Item No.	Report of the Head of Development Management and Building Control	
Address:	56 THE GREENWAY UXBRIDGE	
Development:	Conversion of garage into habitable use including raising of roof and installation of new window. Amendments to front facing fenestration including new windows and front door, along with new iron railing boundary fencing.	
LBH Ref Nos:	35039/APP/2024/1926	
Drawing Nos:	Site Location Plan J2435 - 0 PLAN01 2435 Plan/02	
Date Plans received:	16-07-24	Date(s) of Amendments(s):
Date Application valid	30-07-24

Front elevation

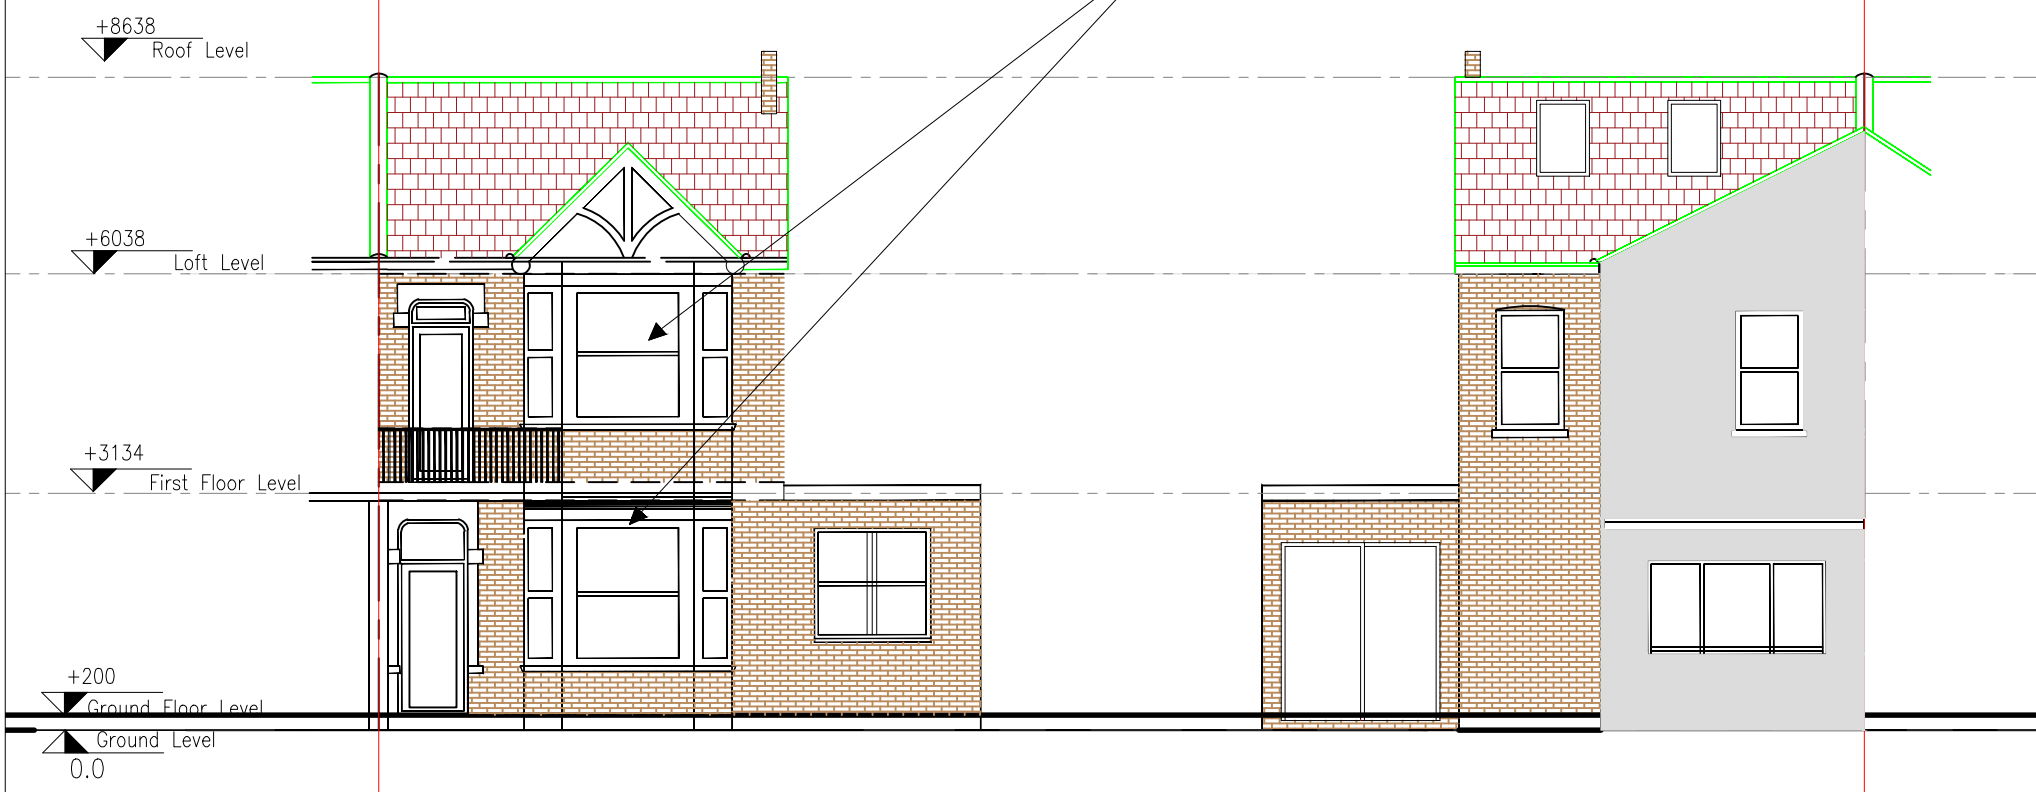
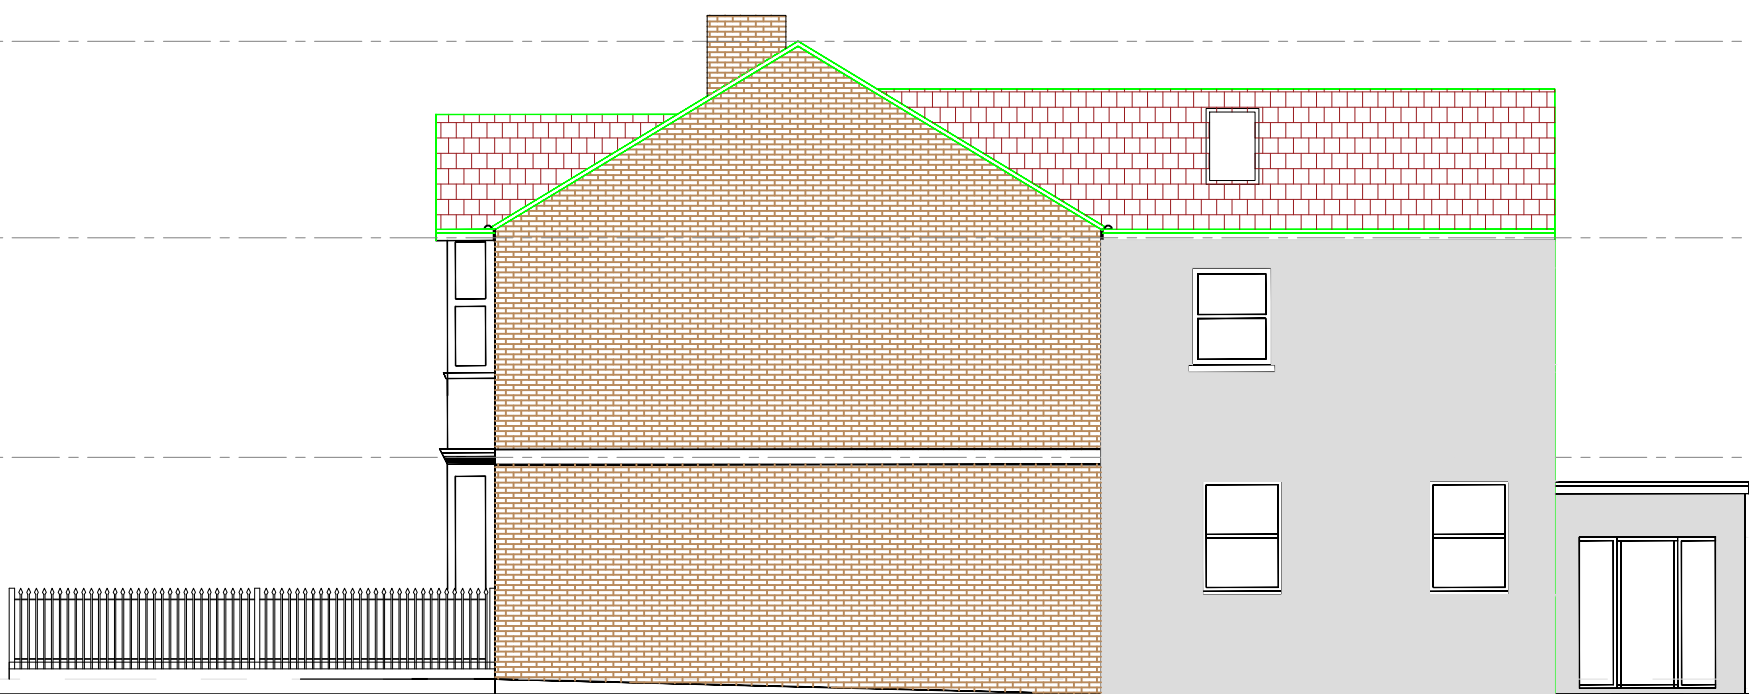
The property forms one pair of a pair which are grand and have fine detailing to the porches and bays using contrasting materials and bricks. The barge boards and gable to the street is also decorative. The loss of the ornate original windows which are a contributing feature of the Conservation Area would result in harm to the heritage asset further exacerbated through the introduction of an out of keeping design and an inappropriate material. The front window to the garage conversion would also relate poorly to the original windows in the front elevation. The applicant has provided examples of nearby upvc windows in support of the application. Officers consider however that the examples provided demonstrate the visual harm to the area. Officers consider that the harm caused is less than substantial and at a moderate level. There are no public benefits before Officers which could outweigh the harm identified.

The proposed replacement of the front bay sash windows with upvc windows and the proposed front facing window in the garage conversion would fail to respond to the architectural integrity of the host building and would fail to conserve or enhance the character and appearance of this building which lies within the Greenway Conservation Area. and there are no public benefits that would outweigh the identified less than substantial harm. The proposal would therefore be contrary Policies BE1 and HE1 of the Hillingdon Local Plan: Part One - Strategic Policies (2012), Policies DMHB 1, DMHB 4, and DMHB 11 of the Hillingdon Local Plan: Part Two- Development Management Policies (2020), Policies HC1, D3 and D4 of the London Plan (2021) and Paragraphs 205; 206; 207 and 208 of the NPPF (2023) and Section 72 of the Planning (Listed Buildings and Conservation Areas) Act 1990 (as amended).
